Submission – Application Number SSD-8530563 – Gunnedah Waste Facility

UNLOADING & PROCESSING SHED PLAN

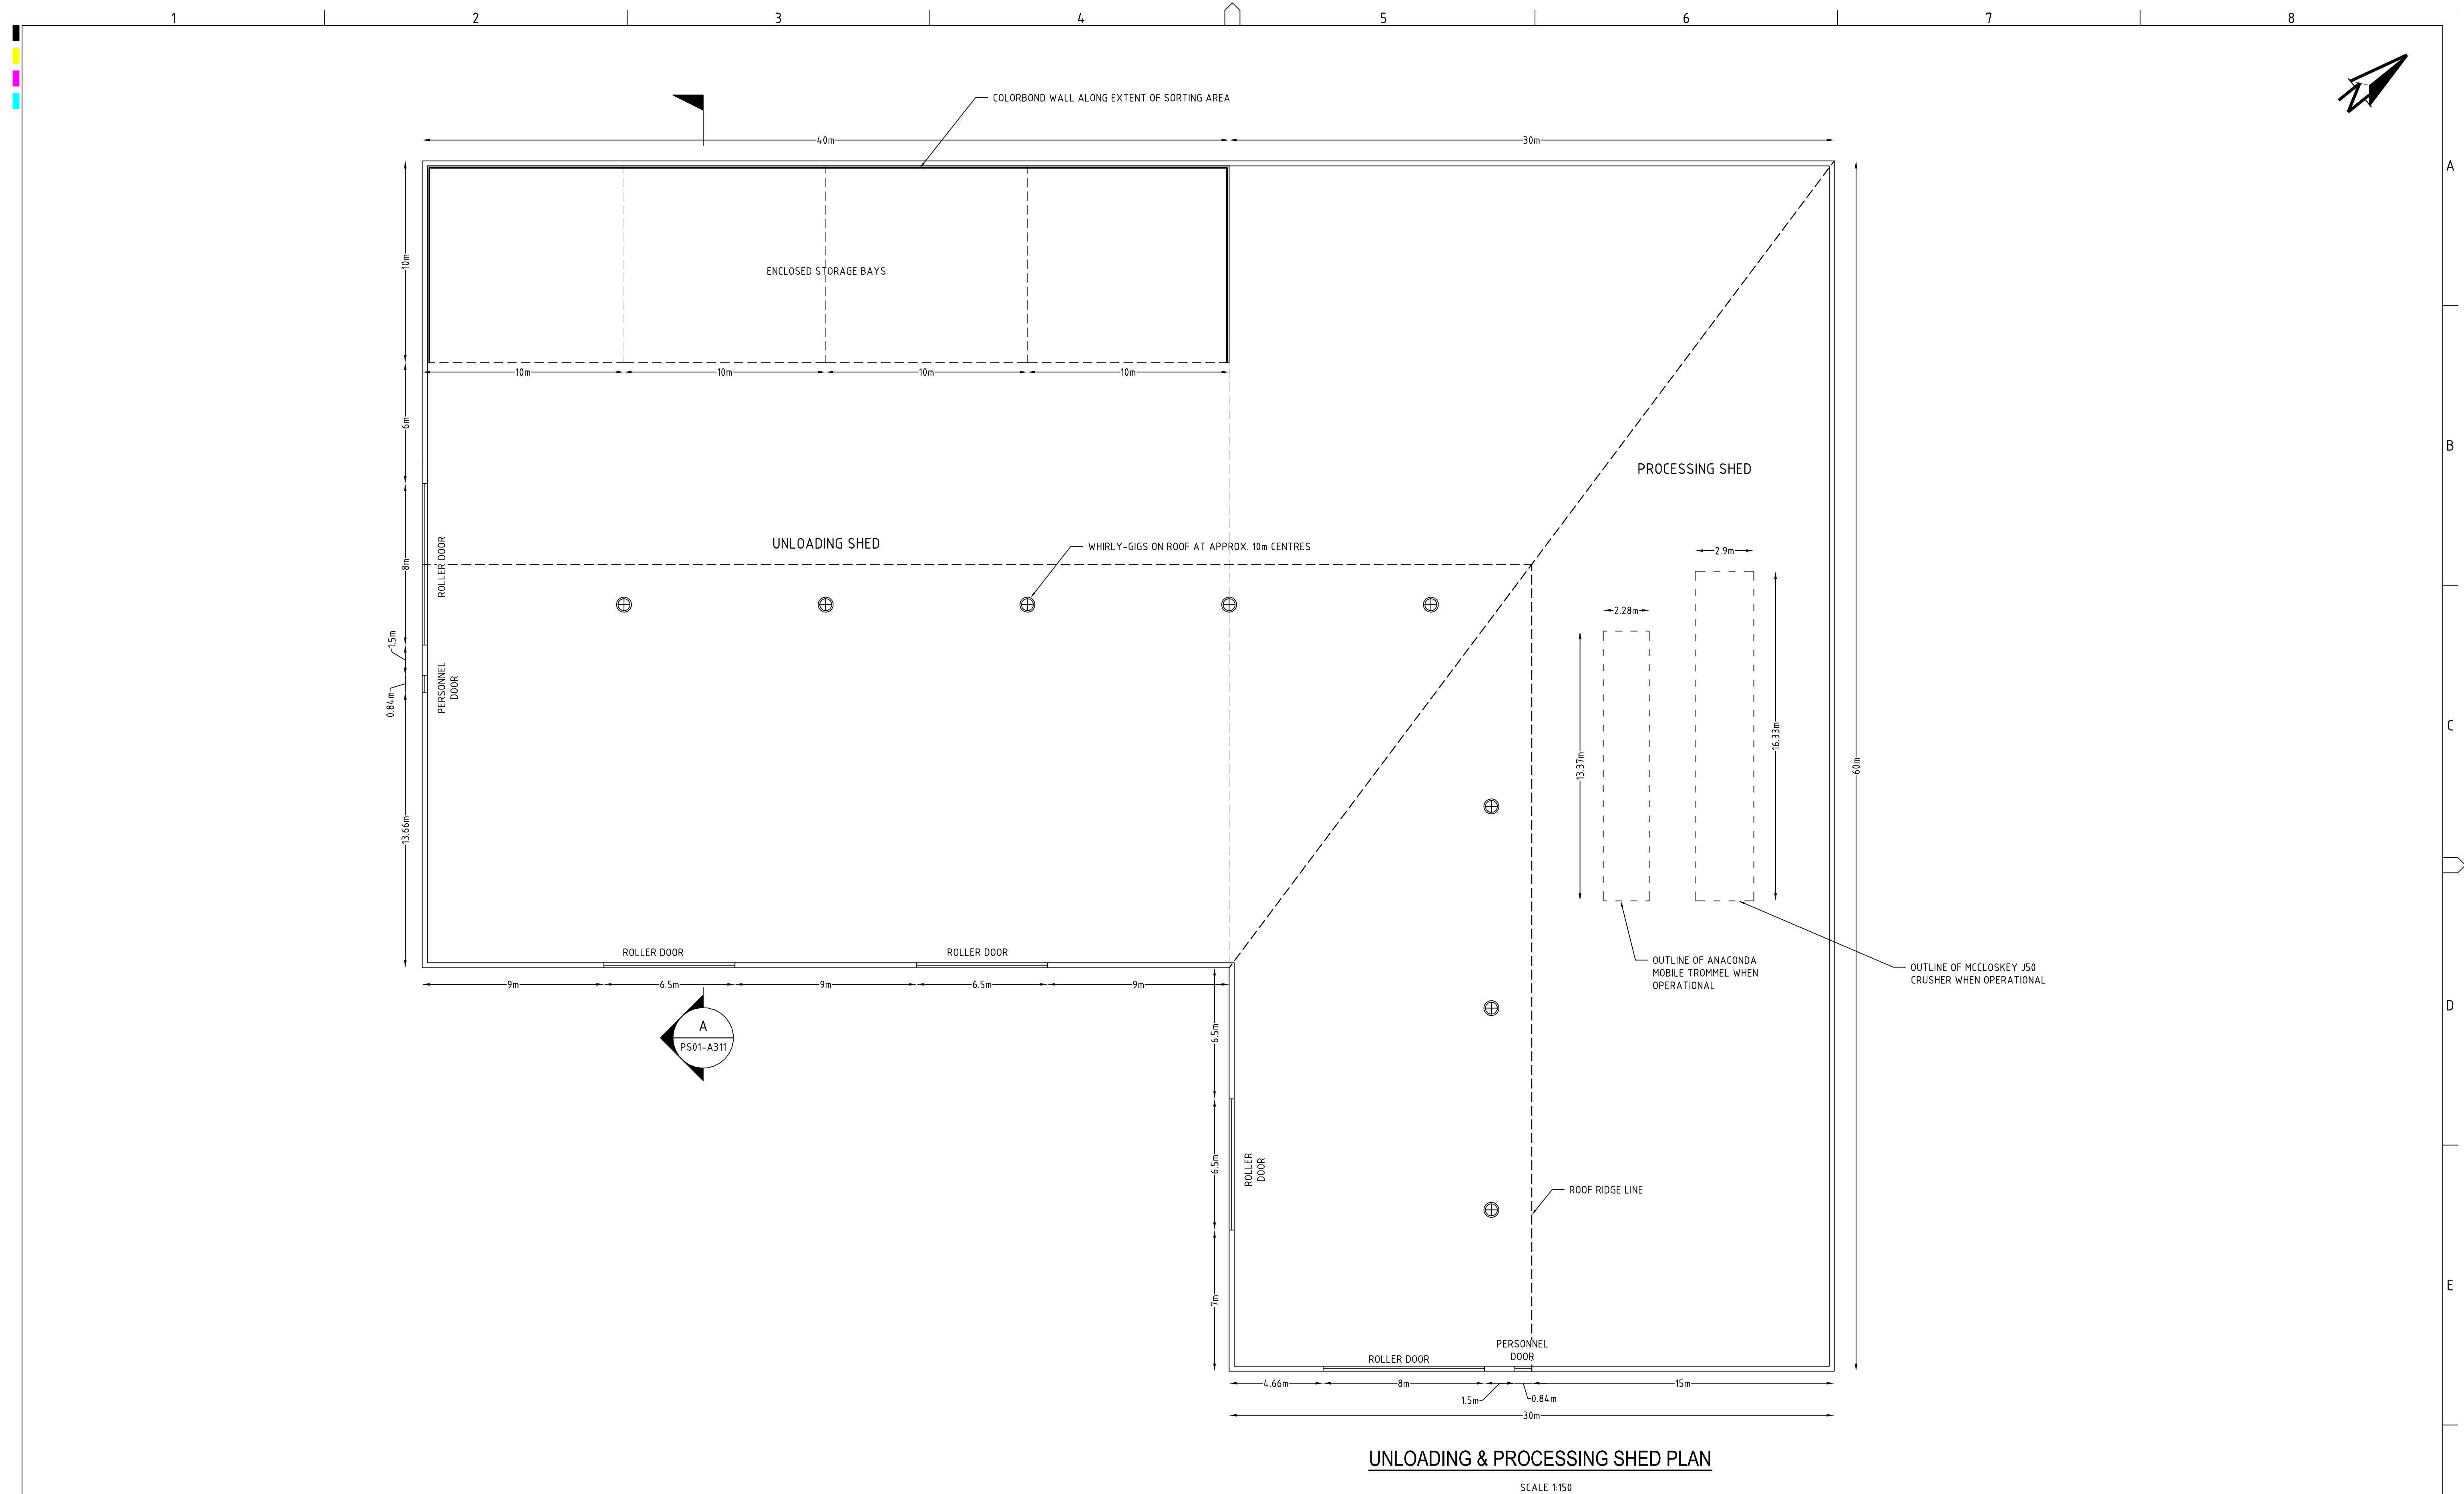
Provide development plans for storage bays including specific elevation and design of each structure. The development should address the visual impact from a 4.5 metre high concrete structure on the adjoining lots and the potential for overshadowing of the site and adjoining allotments.

POST-DEVELOPMENT OSD CATCHMENT PLAN

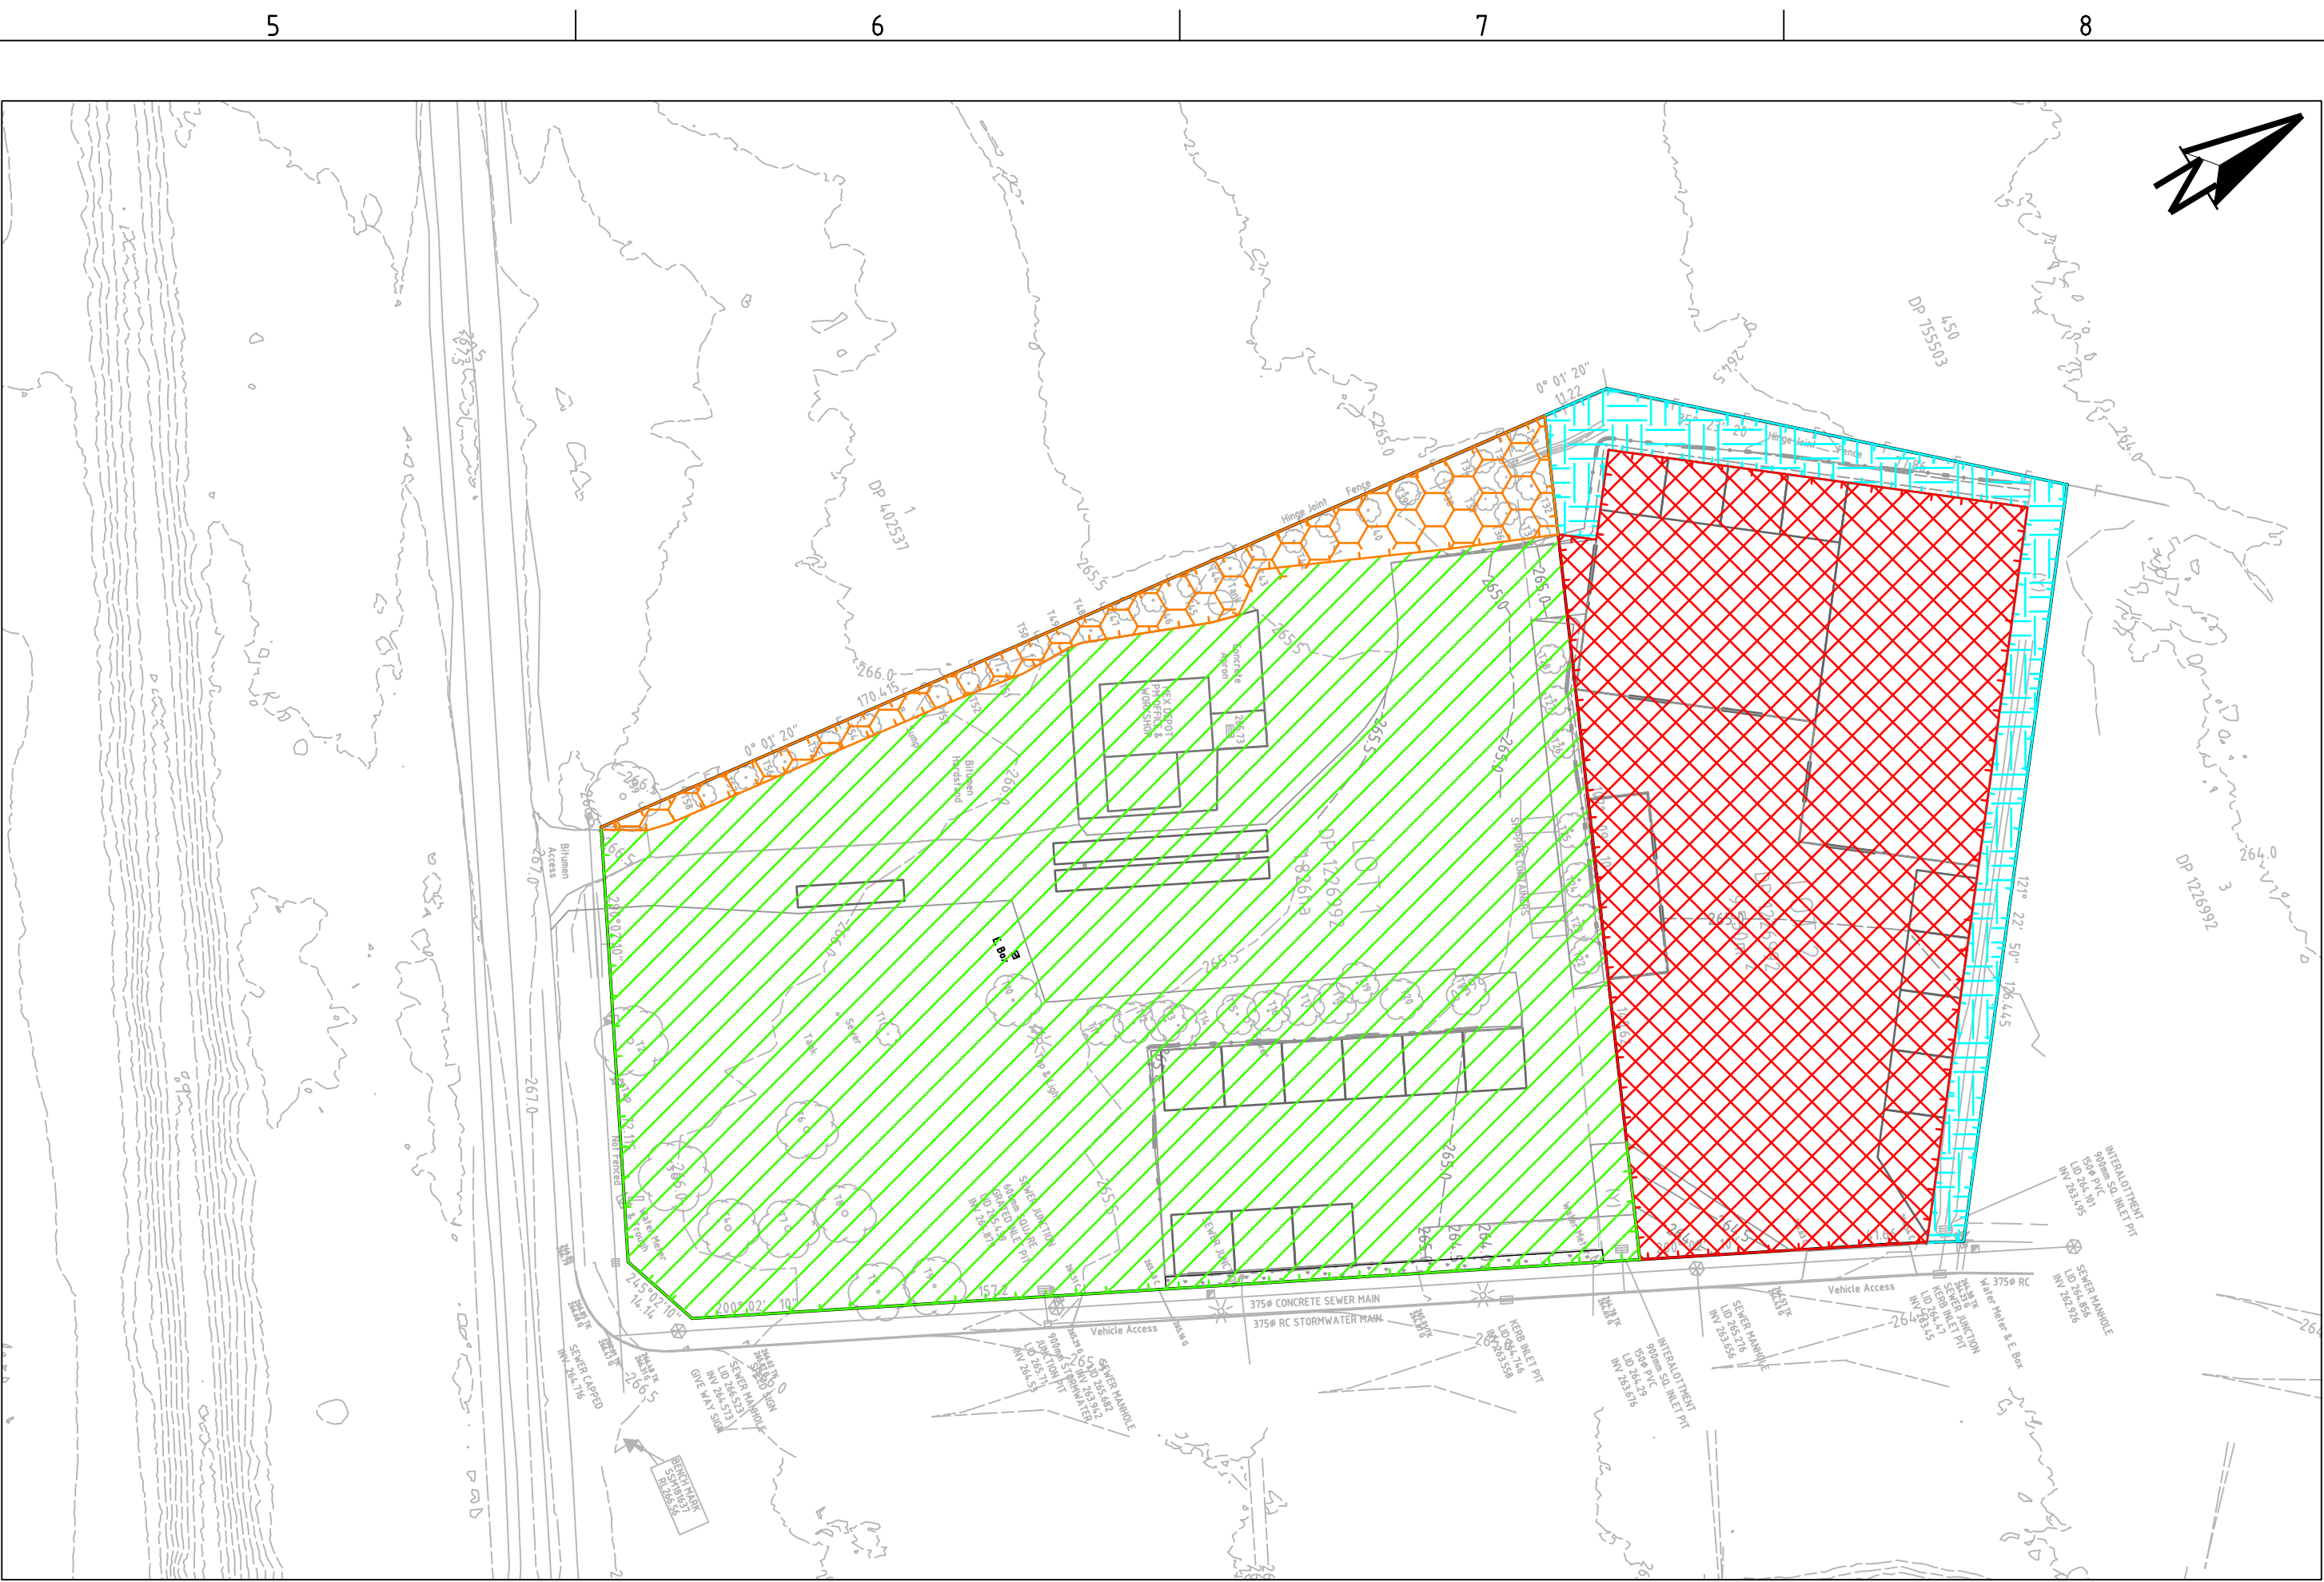
Additional details are required in regard to how the development will prevent the discharge of pollutants from the site. How will spills and particulates transported in stormwater be contained onsite to prevent the discharge to Council's stormwater network or into natural water course?

Stormwater is to be managed within the site with no effluent or polluted water to be permitted to Council's stormwater network or permitted to leave the site. All stormwater works are to comply with the relevant Australia Standards.
